Application Ref:		3/2026/0675		 Ribble Valley Borough Council www.ribblevalley.gov.uk	
Date Inspected:	N/A	Site Notice:	N/A		
Officer:	MC				
DELEGATED ITEM FILE REPORT:				Decision	APPROVAL

Development Description:	Prior notification for roofing over existing building to prevent run off under Part 6 Class A of the GPDO
Site Address/Location:	Bolton Fold Farm, Alston Lane, Longridge, PR3 3BN

PROPOSED ELEVATIONS
(Sheet 1 of 2)

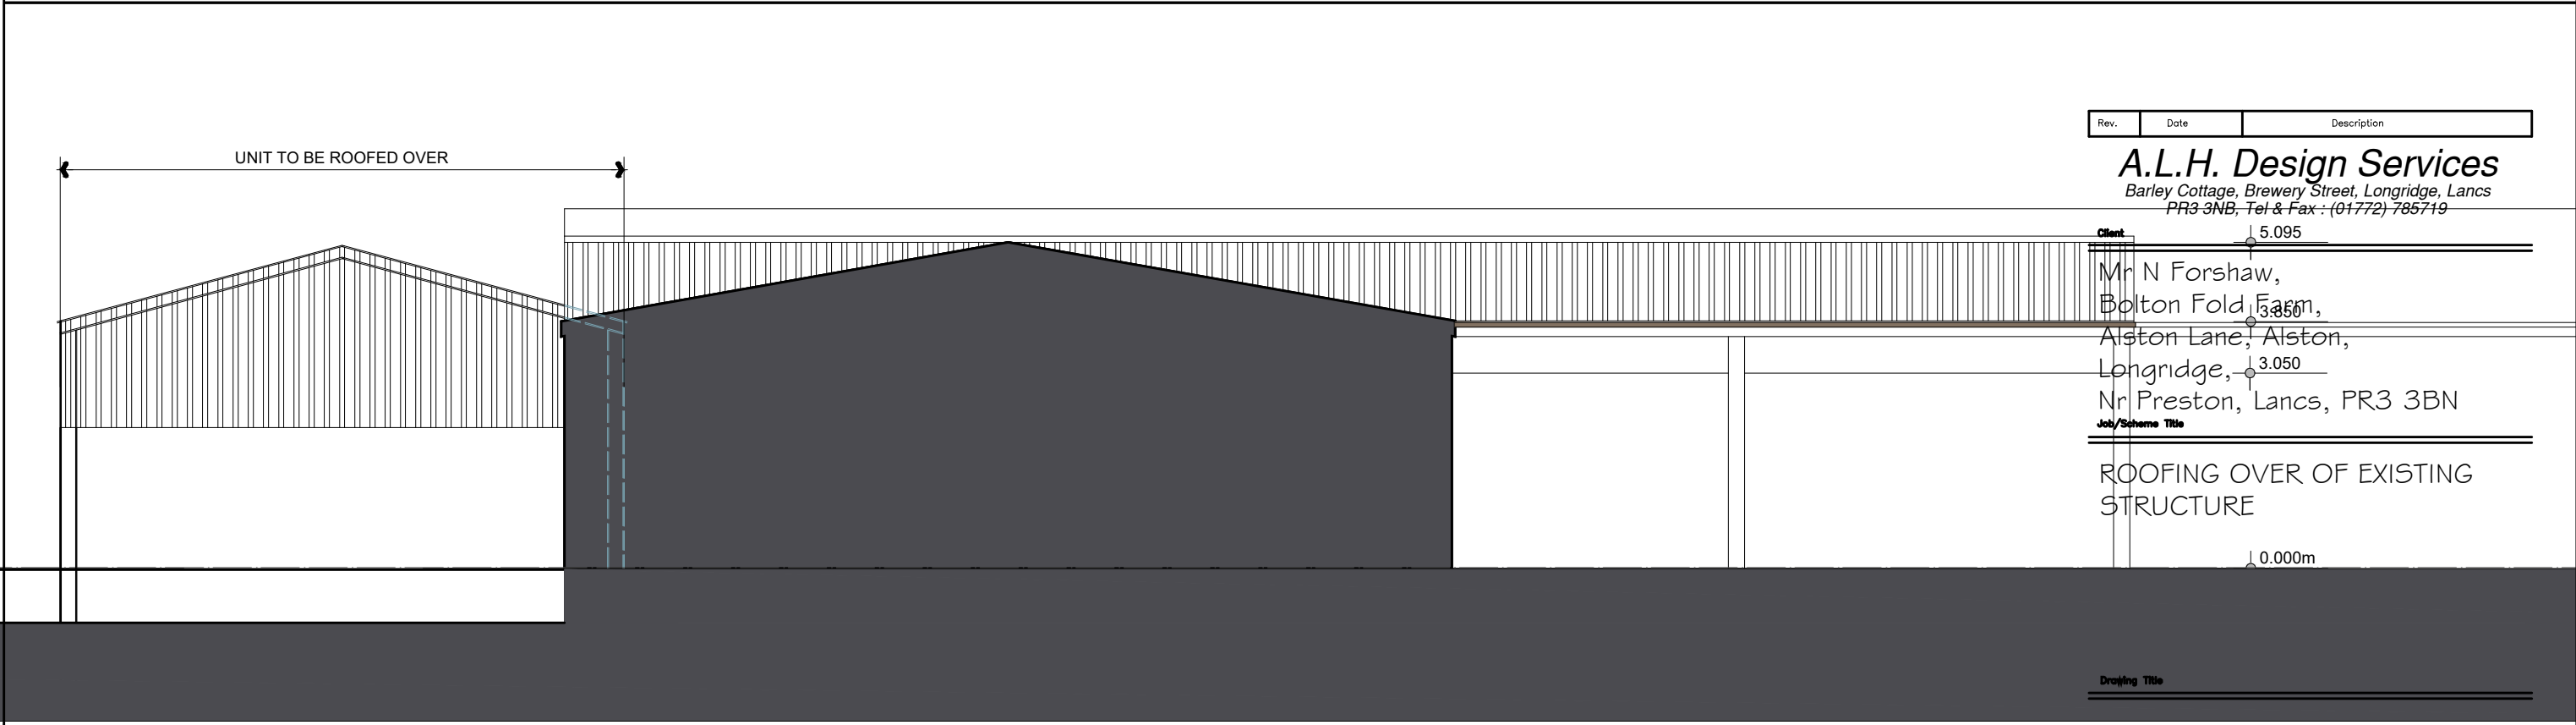
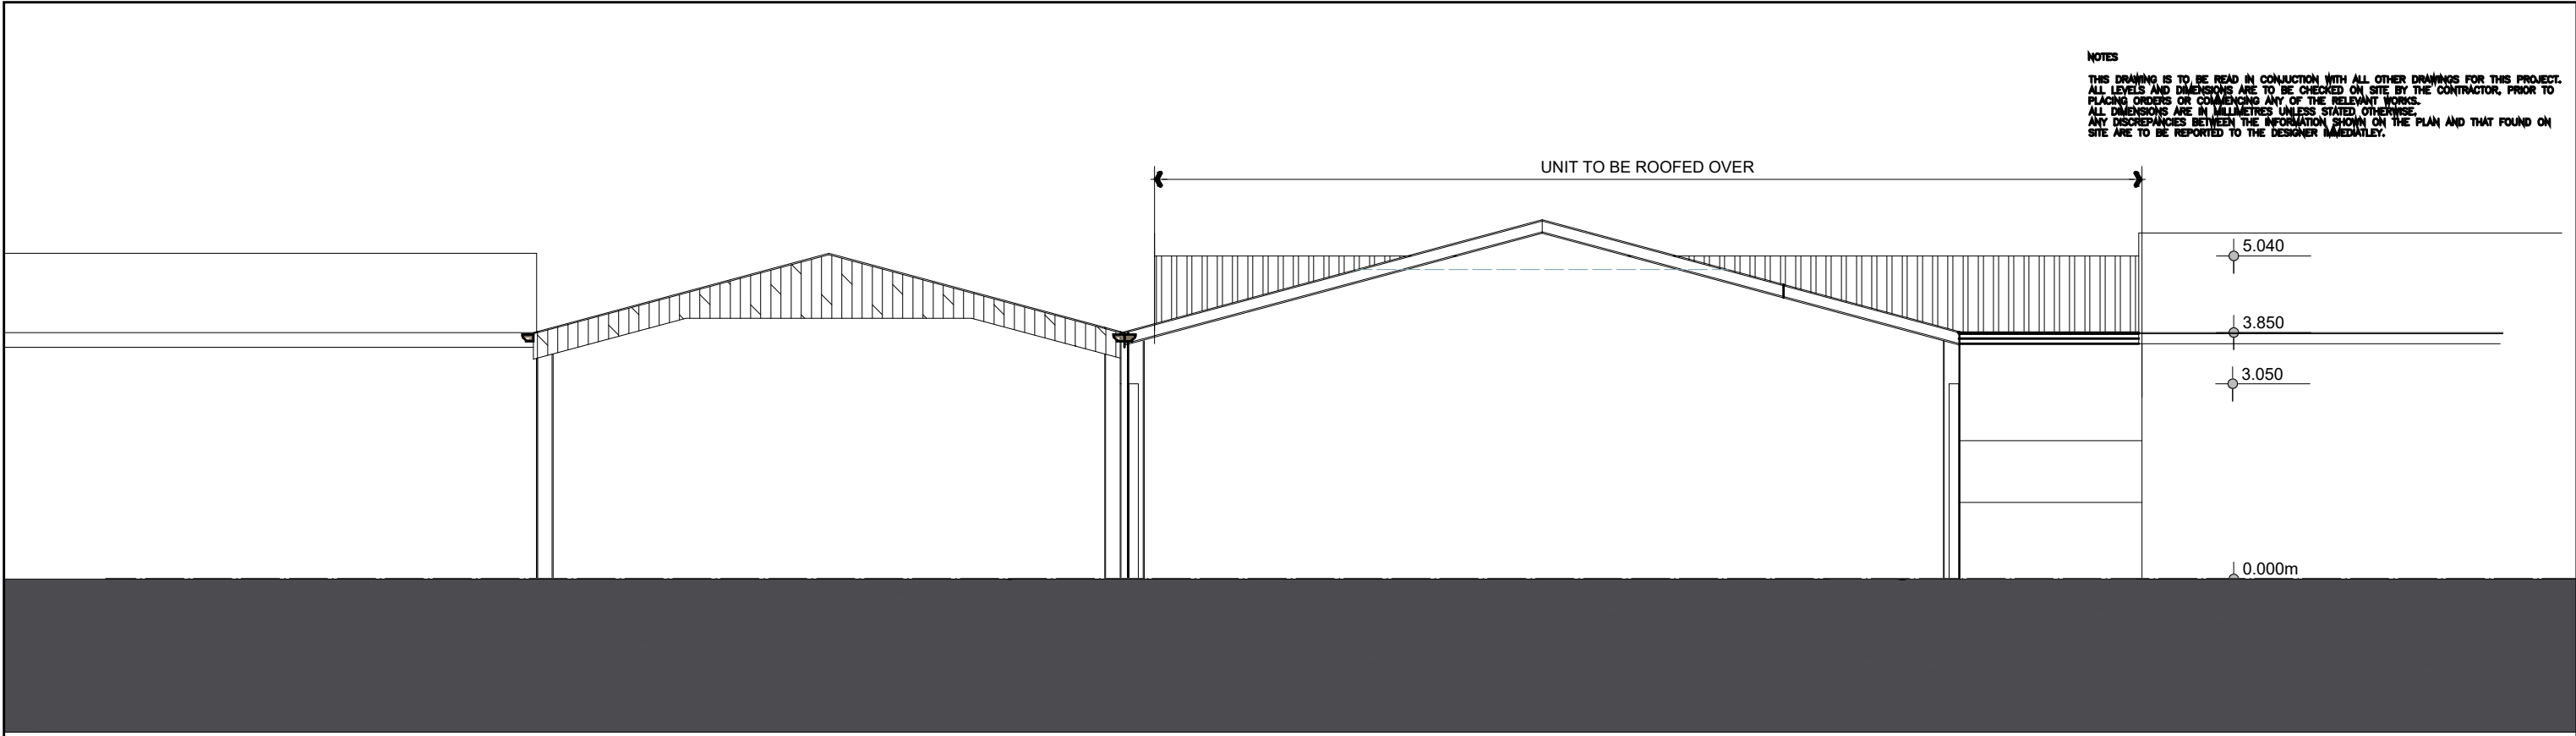
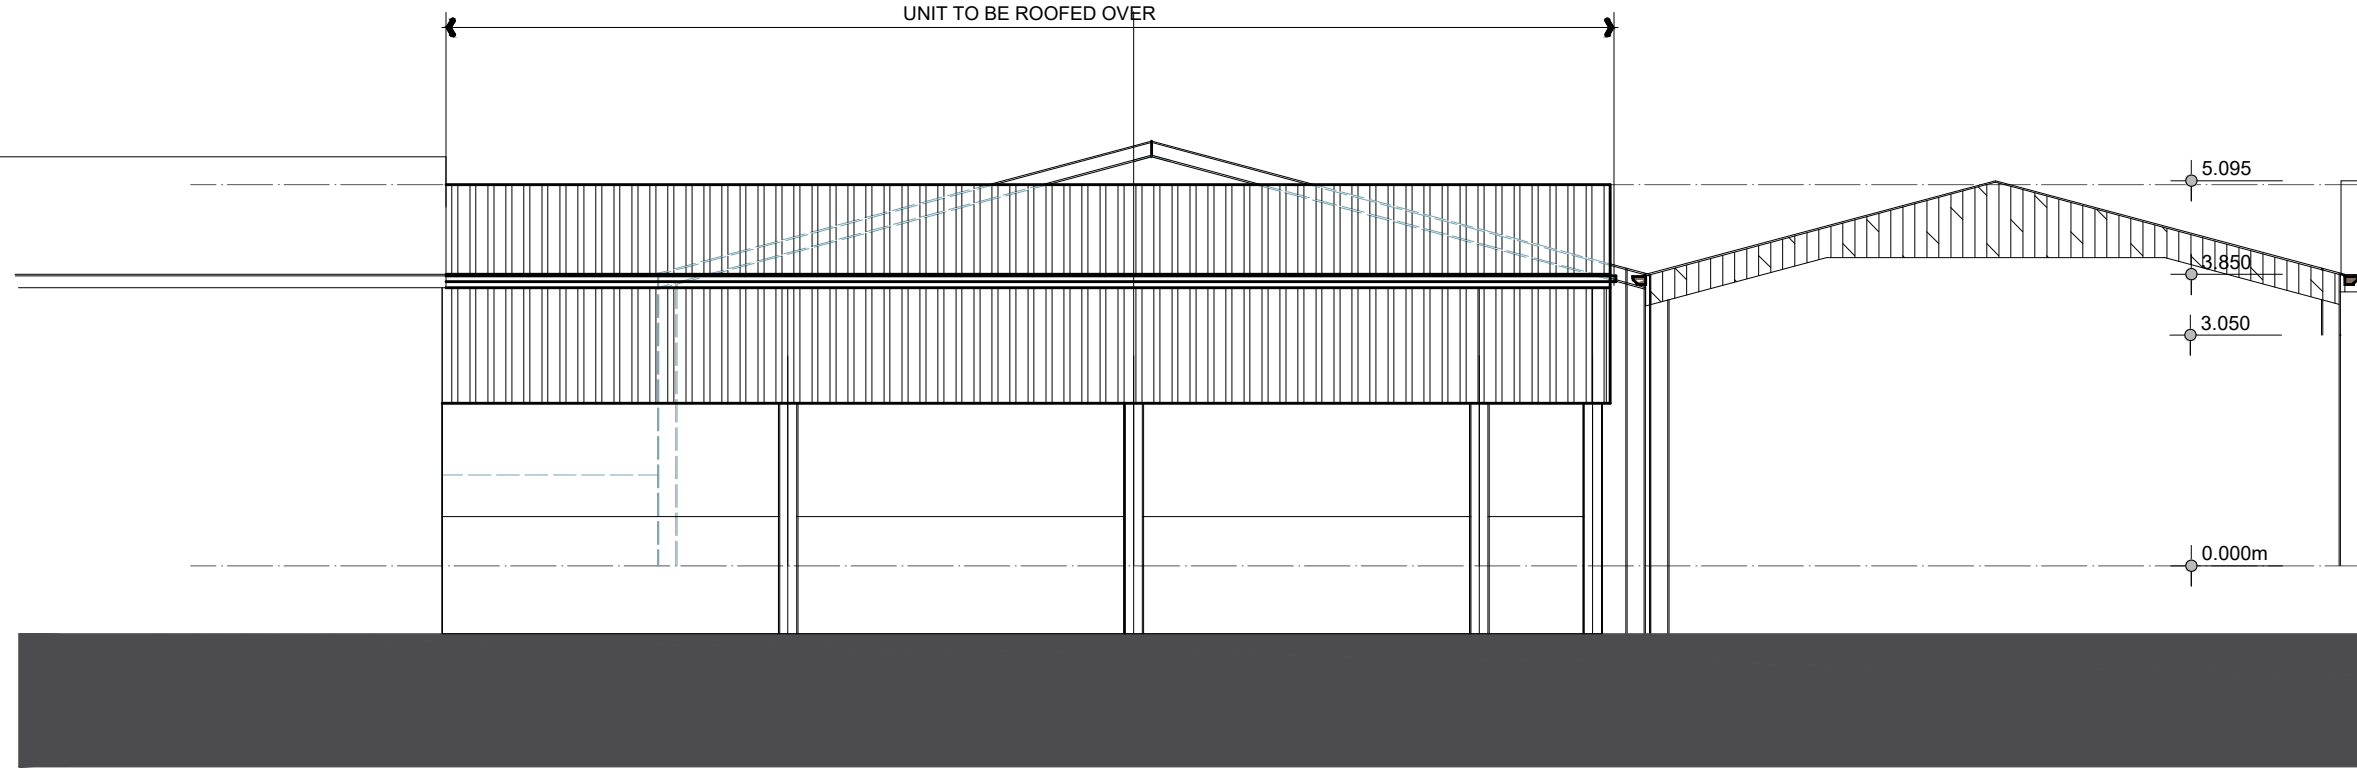
The proposed building would be approximately 15.18m x 8.8m by 5.1m and would be constructed of juniper green profiled cladded panels with existing grey concrete aprons.

The proposed building would have a maximum height of 5.1 metres in height.

Siting – The application site is located within the existing farmstead and is sited immediately adjacent to existing agricultural buildings and would therefore be read within the context of existing built form. Elevations have been submitted which indicate that the building would be similar in height to the adjacent buildings. The building would not be highly visible from the public realm, being sited adjacent to existing structures. As such, it is not considered that the development would result in harm to the landscape character of the open countryside.

Design / appearance – The building would be of an appropriate size and scale in relation to existing agricultural buildings within its immediately surroundings. The building would utilise juniper green cladding and it is noted that the adjacent agricultural buildings comprise a mix of green cladding and timber boarding. As such, the design and materials would not be out of keeping with the surrounding area.
